WST11/00046/05

Hera Gold Project (10_0191 MOD 2) Modification to Haulage Route

Thank you for your email received 11 June 2014 requesting comments on the modification to the haulage route for Hera Gold Project from Roads and Maritime Services. Roads and Maritime notes that the modification proposes to change the haulage route with impacts on the Barrier Highway at Hermidale.

Figure 3: Proposed haulage route to Hermidale rail siding

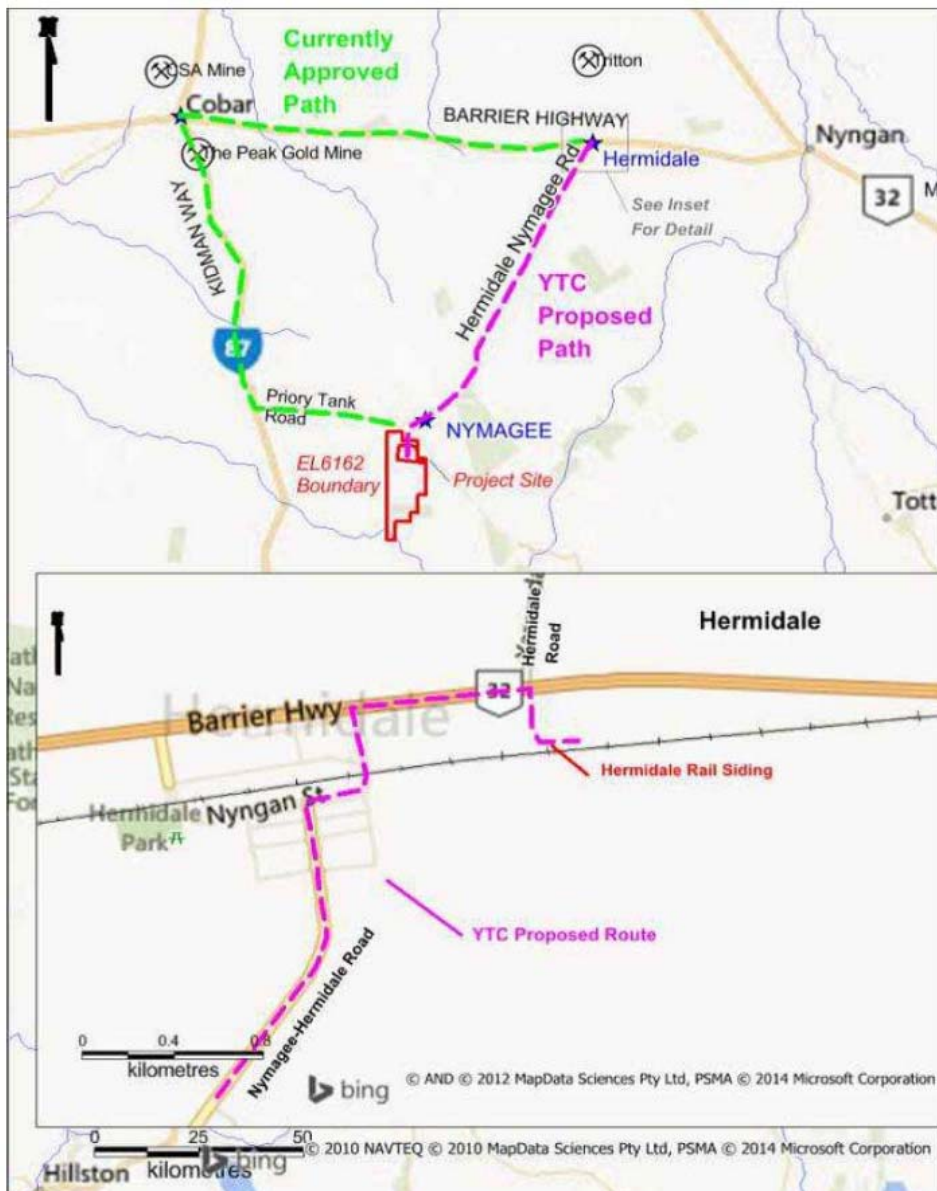
The proposed haulage route includes a right turn onto the Barrier Highway from Nyngan Street at Hermidale, trucks travelling about 600m along the Highway, then turning right into the rail siding. The speed zone on the Barrier Highway is 110km/h and the application does not propose any intersection treatments to cater for the acceleration or deceleration of the haul vehicles. Roads and Maritime is concerned about the safety of the travelling public on the Highway, as well as safety for the haulage vehicle operators given the mix of slow moving haul vehicles with high speed through traffic.

The applicant has not demonstrated why access cannot be obtained via the local road network rather than using the Barrier Highway. Roads and Maritime does not support the proposal and strongly recommends that access to the siding be obtained via the local road network. Roads and Maritime requests additional information be provided showing access to the rail siding via the local road network.
